From: Michael Eastham
Sent: 11 March 2019 12:51
To: [REDACTED]
Cc: [REDACTED]
Subject: FW: WA/95/18/RES

Please see the email below which sets out the consultation response from Environmental Health to **WA/95/18/RES** – Land East of Tye Lane, Walberton.

From: Fiona Fitzgerald
Sent: 11 March 2019 12:23
To: Planning.Responses
Cc: Michael Eastham
Subject: WA/99/18/RES

PLAY & RECREATION DIAGRAM

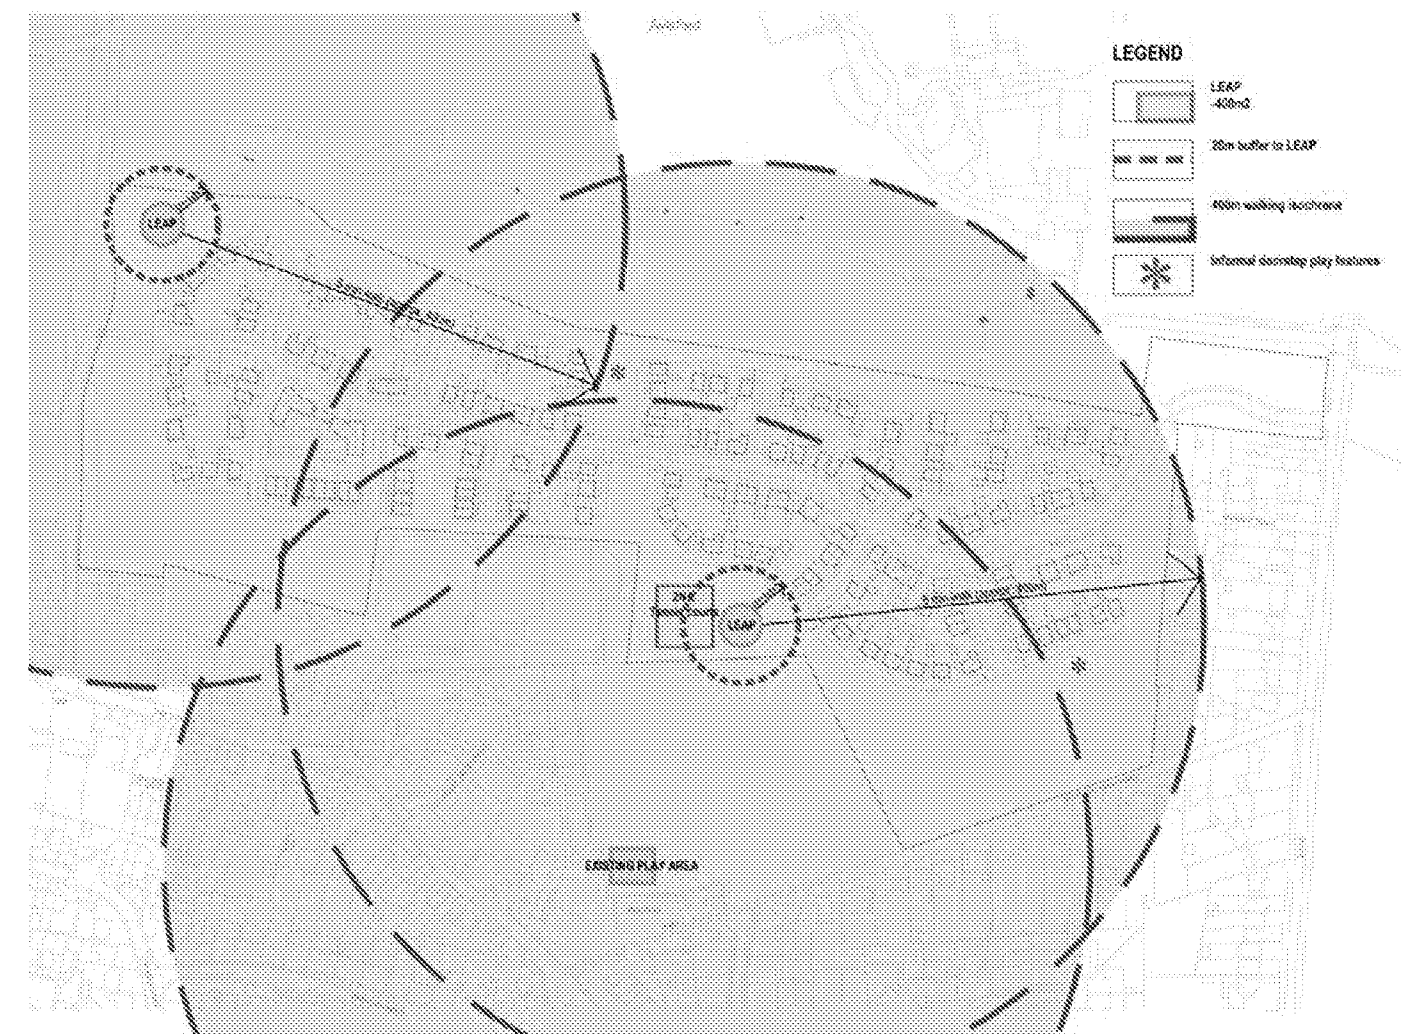
1. No floodlights or other forms of external lighting shall be installed or used at the tennis courts.
2. The tennis courts shall only be used between the hours of 07.00 and dusk daily.
